Application Ref:	3/2026/0569			 Ribble Valley Borough Council www.ribblevalley.gov.uk
Date Inspected:	04/09/26	Site Notice:	04/09/26	
Officer:	LW			
DELEGATED ITEM FILE REPORT:				APPROVAL

Development Description:	Proposed installation of solar PV panels to roof.
Site Address/Location:	2 The Walled Garden, Woodfold Park, Mellor, BB2 7QA.

Proposed South Elevation

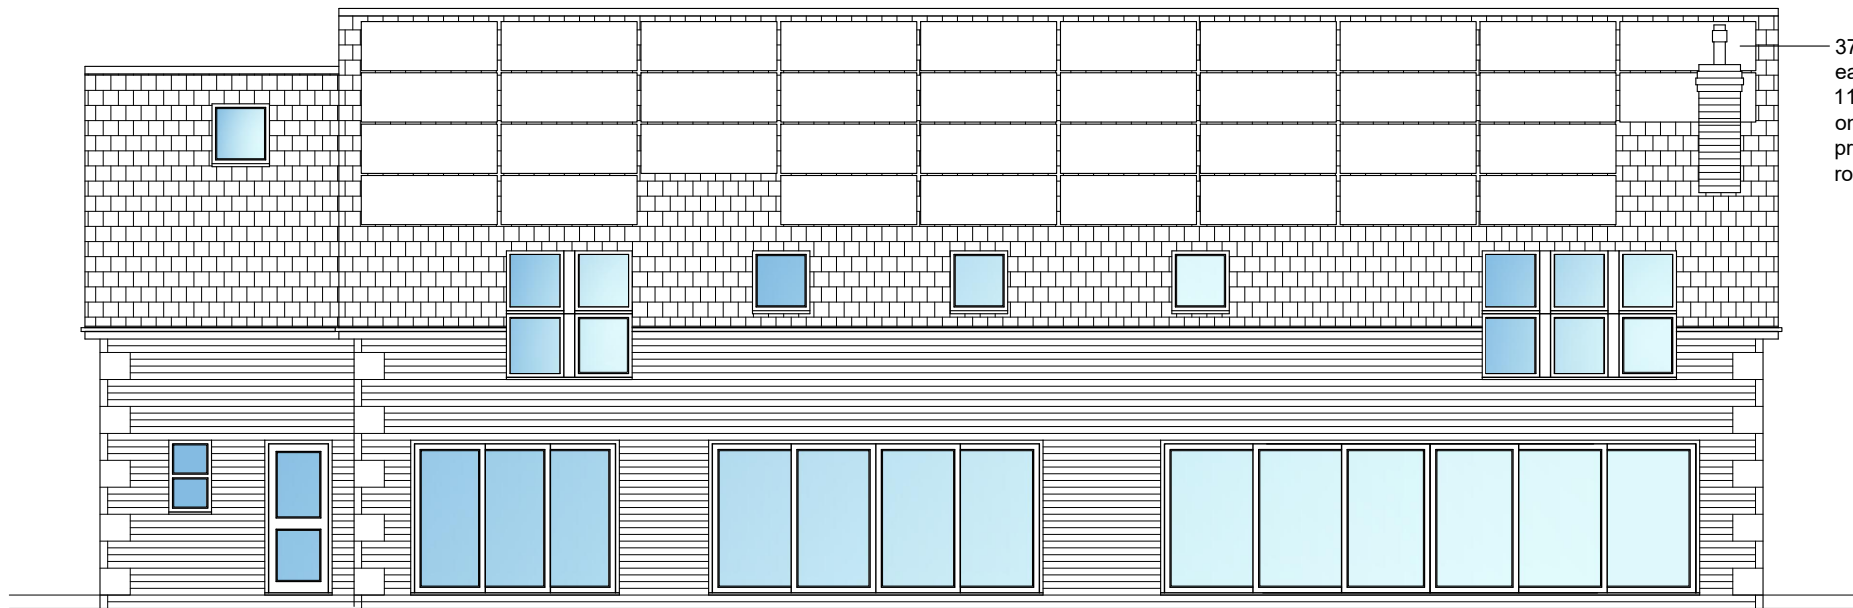
Whilst the installation of proposed solar photovoltaic panels would be viewed in the context of the dwelling's more modern rear elevation, the scheme as originally submitted proposed 37 solar panels covering the majority of the rear roof slope.

The application property occupies an elevated position, with land levels falling away to the south. As a result, the rear elevation and roofscape are visible from parts of the parkland, particularly towards the north-western area of Woodfold Park. Concerns were therefore raised by the LPA that the extent and coverage of the originally proposed solar arrangement would cause the panels to become the dominant feature of the roofscape when viewed from these vantage points to the detriment of the character and appearance of the property and the surrounding historic parkland.

Amended plans have subsequently been received reducing the number of solar panels from 37 to 16. The panels are now centrally positioned, set in from the gable ends and comfortably below the ridge and above the eaves. The revised arrangement results in a significantly more balanced and discreet appearance, allowing substantial areas of the roof to remain visible. Consequently, the proposed solar installation would be read as a subordinate addition to the dwelling rather than the defining feature of the roof slope.

Overall, the amended proposal is considered a more proportionate and sympathetic form of development compared to the scheme originally submitted with the application. By virtue of the reduced number of panels and their revised arrangement, the installation would not appear as an unduly prominent or dominant feature within views of the dwelling from the surrounding parkland. The proposal would preserve the character and appearance of the host dwelling, conserve the significance of Woodfold Park as a Grade II Registered Park and Garden, and preserve the settings of Woodfold Hall and its orangery. Accordingly, the development is considered to accord with Chapter 20 of the NPPF, the statutory duty under Section 66(1) of the Planning (Listed Buildings and Conservation Areas) Act 1990, and Key Statement EN5 and Policies DME4 and DMG1 of the Ribble Valley Core Strategy.

Proposed Roof Plan

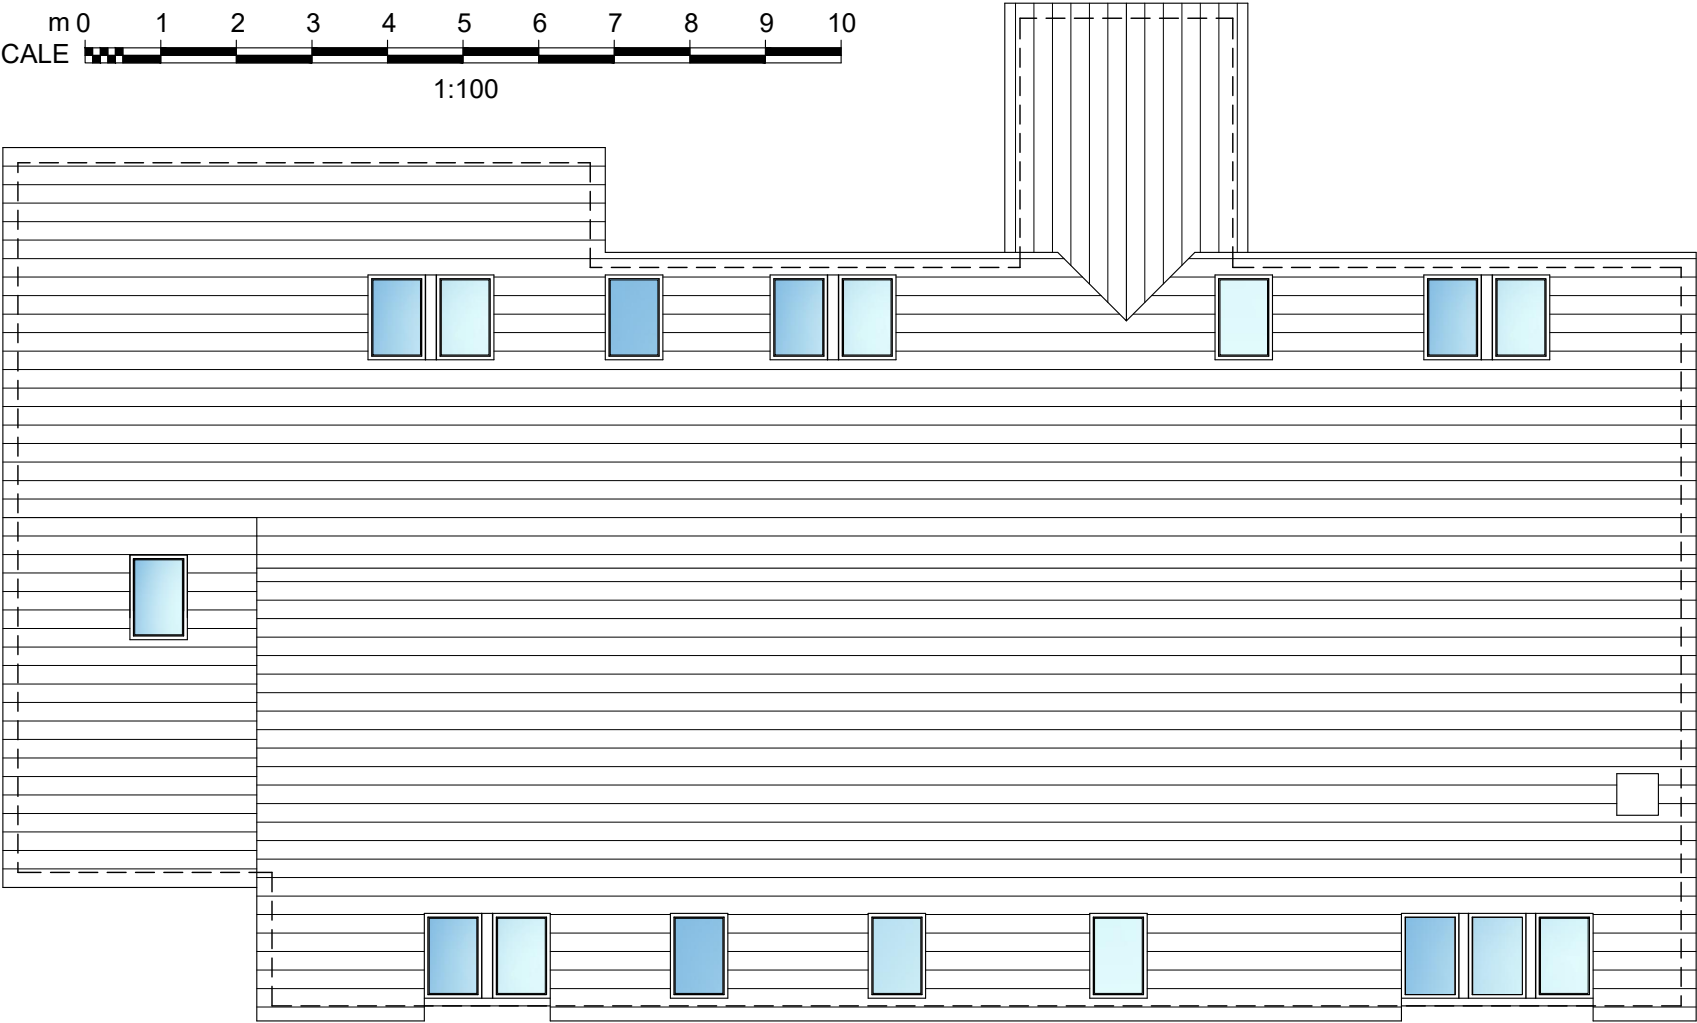
In an attempt to address these concerns, amendments were sought to reduce the extent of the installation and thereby minimise the visual impact of the development.
